Planning Application No: 3/2022/0280

The application is for the conversion of an outbuilding/garage to a two-storey annex.

Project Name	Project No.	Stage
Pale Farm Barn	139.22	Planning
Proposed Elevations	Scale	1:100 @ A1
<b>P03.01</b>	Date	Mar 2022
Rev --	Drawn	HE

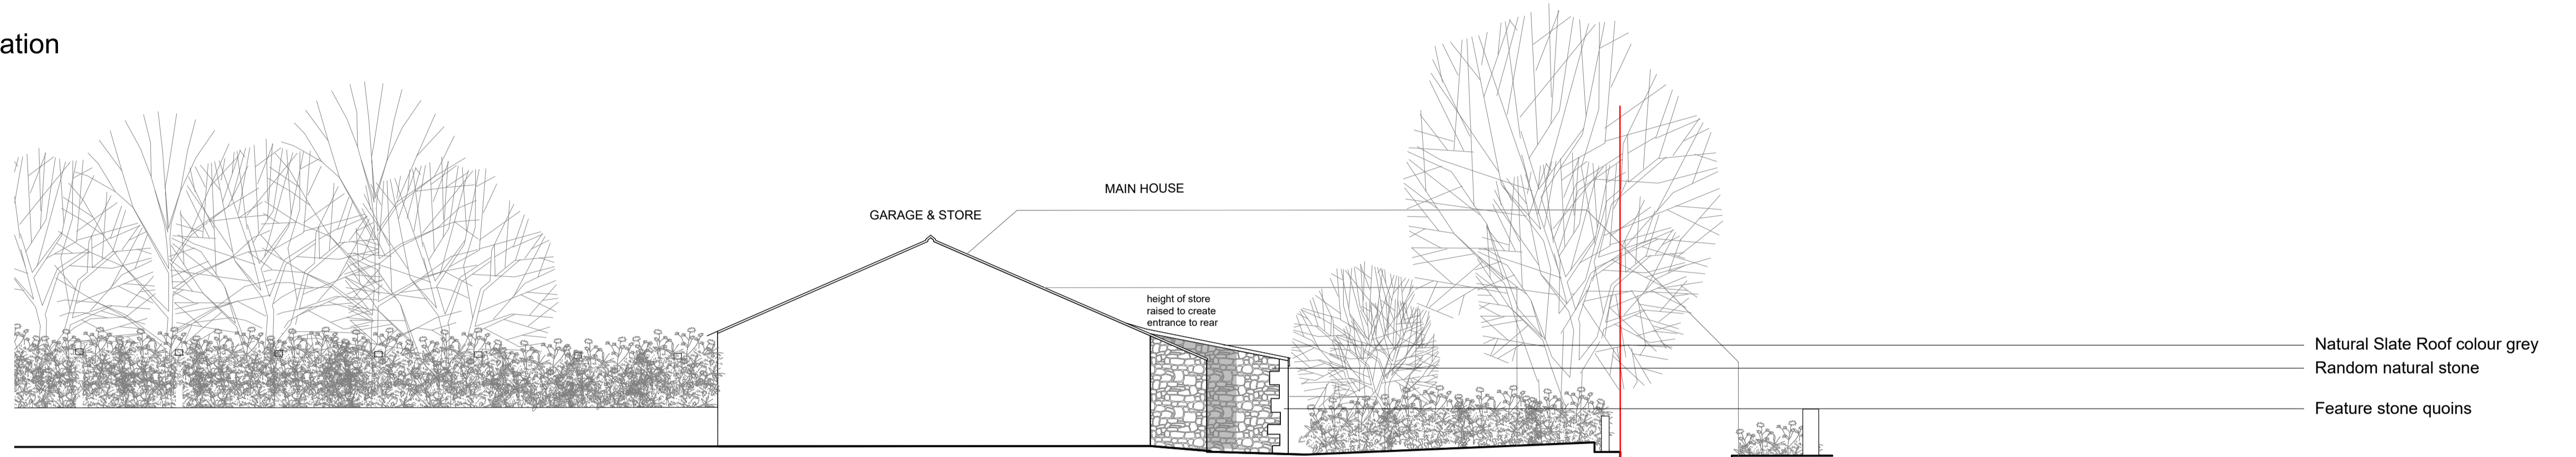
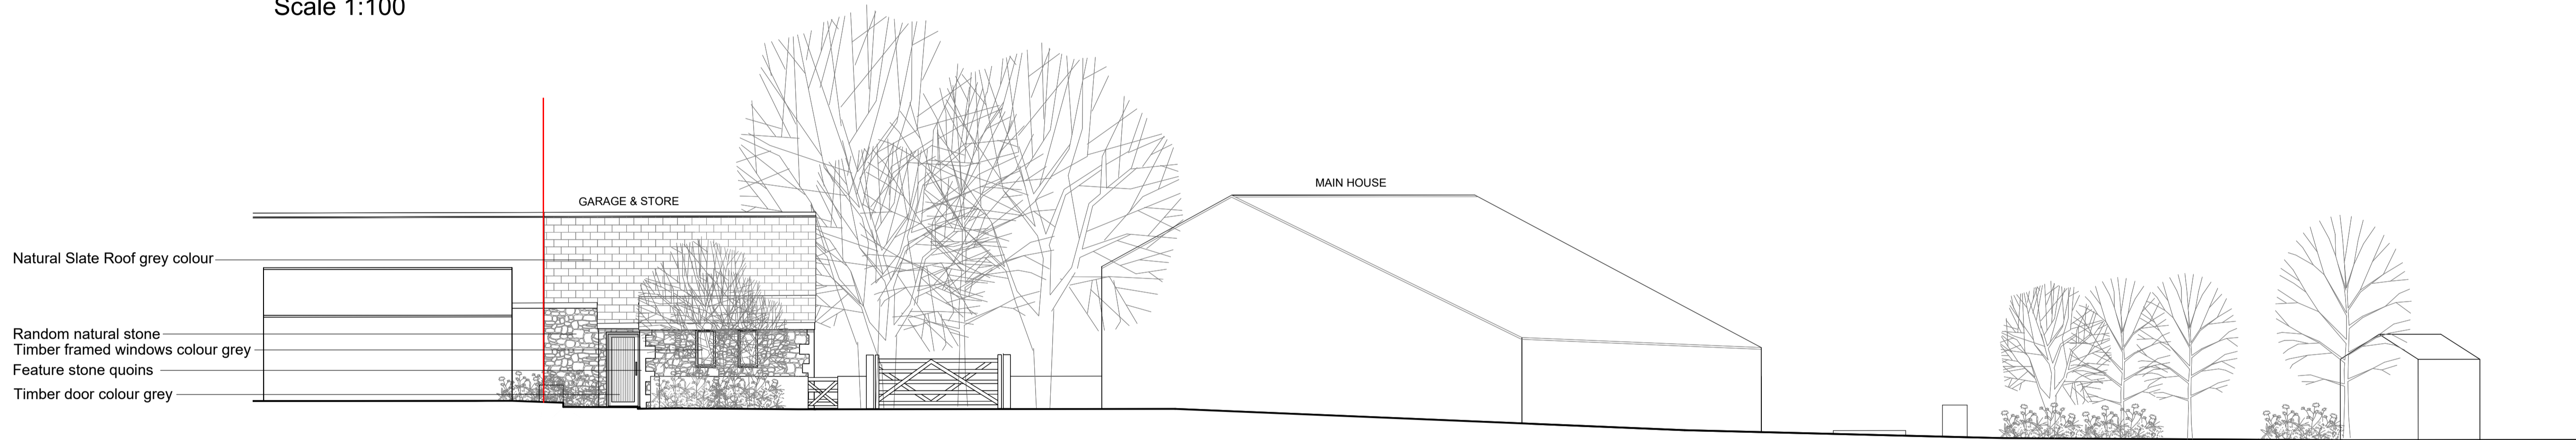
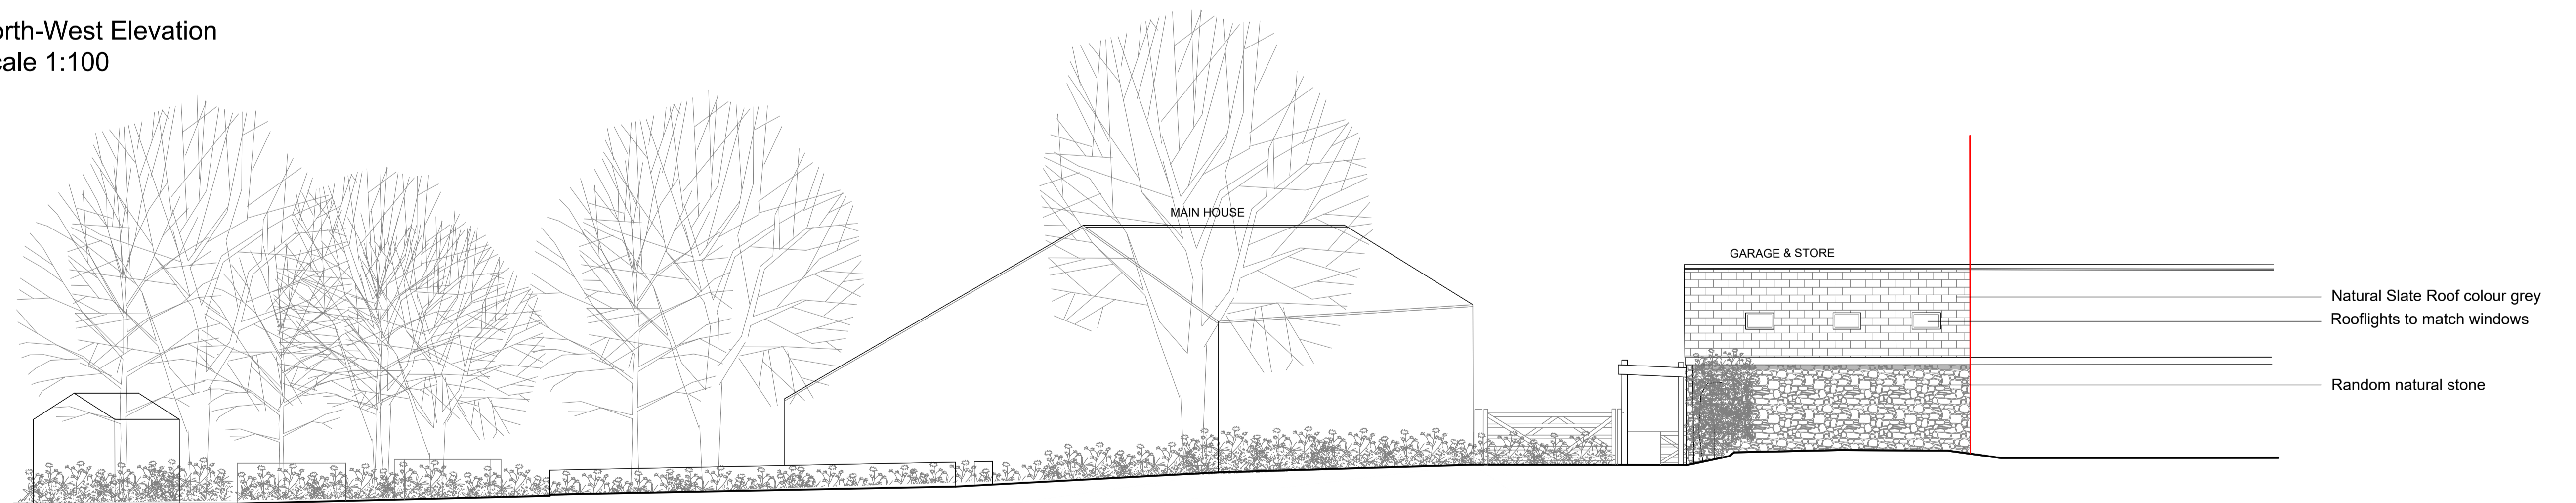
1. The outbuilding is currently used, as the Planning Statement confirms, for storing a car and for storage. When the building is used, [REDACTED] than if it is used as a home/annex with running water and plumbing.
2. The proposed second access point is currently used as a log store [REDACTED]
3. The proposed rooflights on the proposed side elevation [REDACTED] The Planning Statement incorrectly states that they will not be visible due to the hedge boundary.
